Subject:
 22/03873/F

This department has the following response to this application as presented:

Emma Jones
Environmental Protection Officer

TITLE:
DNO Building Details

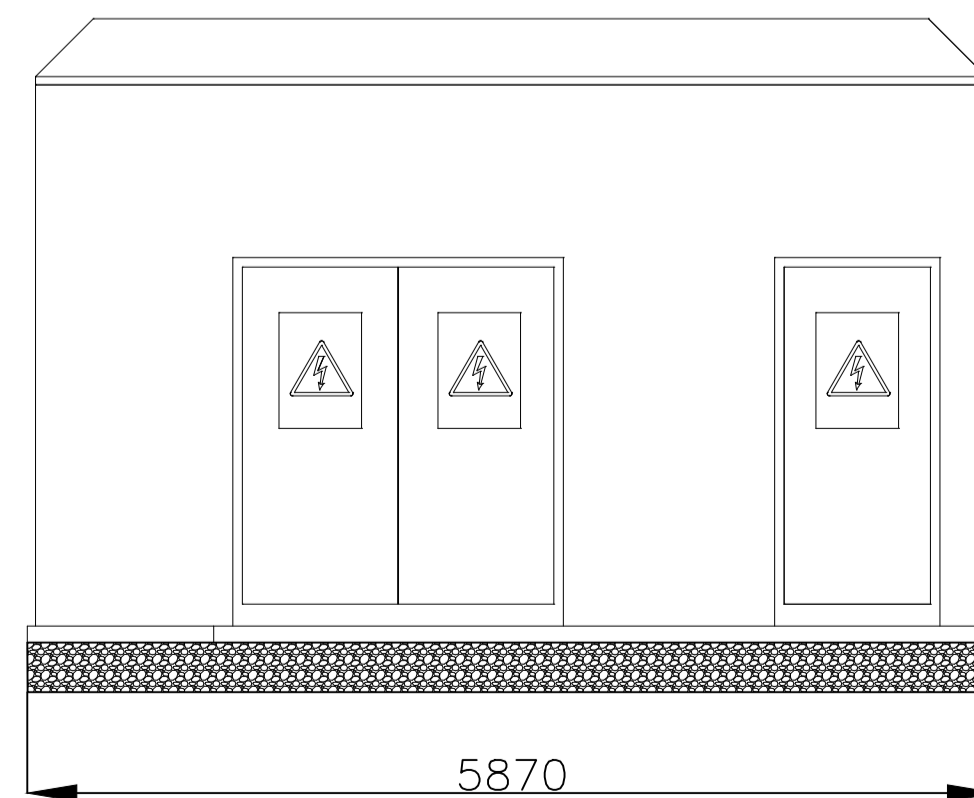
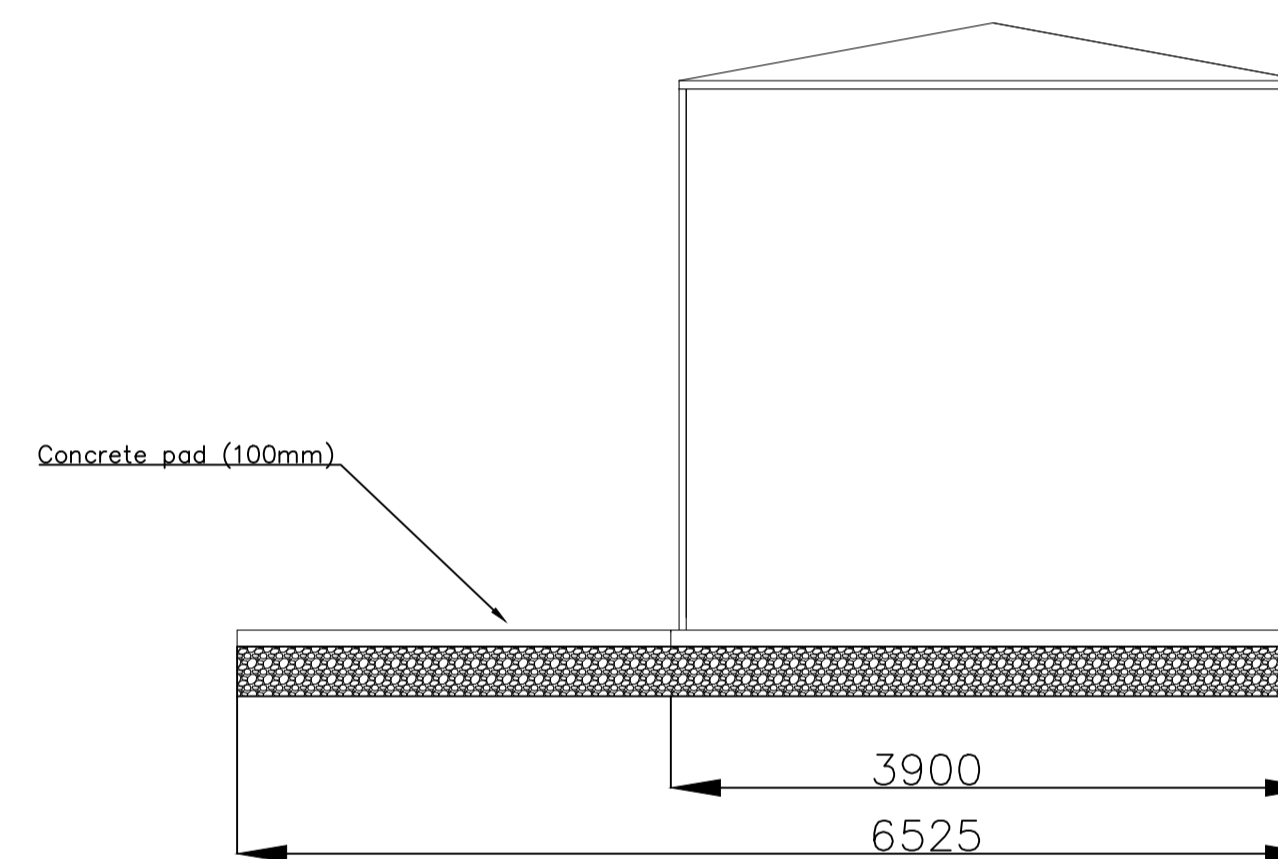
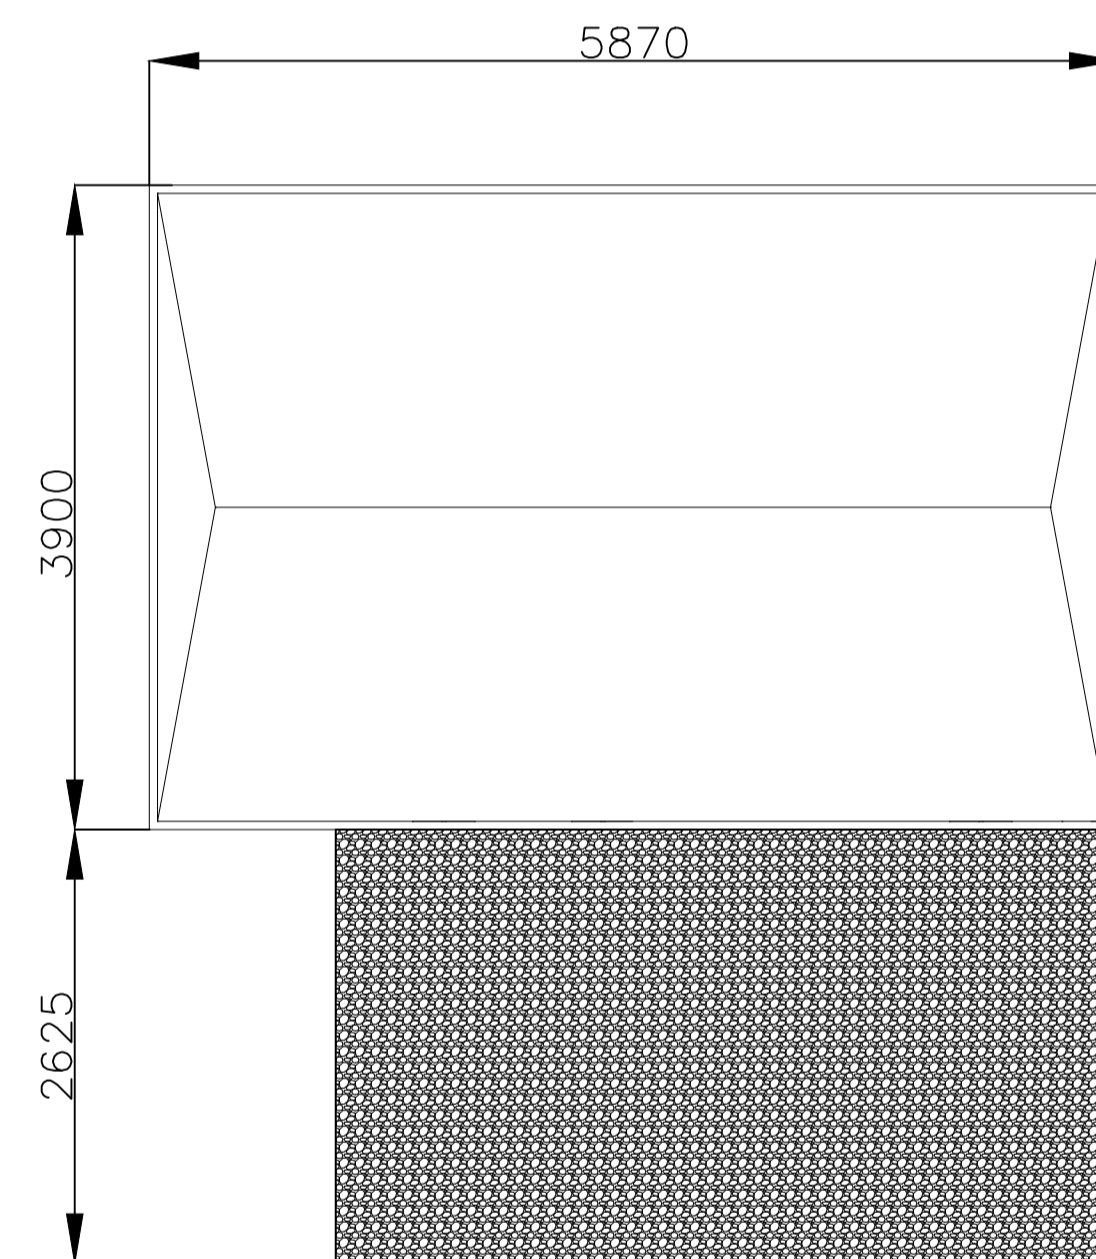
Noise: I have read the Noise Impact Assessment Report provided by the applicant (ref 2061200-RSKA-RP-001, dated January 2023) and noted the predicted noise levels from the proposed inverters and substations which could cause a significant impact to the local noise environment should mitigation not be installed (+20db above background level). I also note that potential mitigation to reduce the noise levels to acceptable levels is discussed but not finalised, therefore I would recommend that the following conditions be placed on any permission granted:

- Prior to the commencement of the development hereby approved, full details of a noise
 mitigation scheme including the noise levels to be achieved with the mitigation at the Noise
 Sensitive Receptors listed in the noise report (ref 2061200-RSKA-RP-001, dated January
 2023) shall be submitted to and agreed by the LPA. Thereafter, and prior to the first use of
 the development, the development shall be carried out and retained in accordance with the
 approved details.
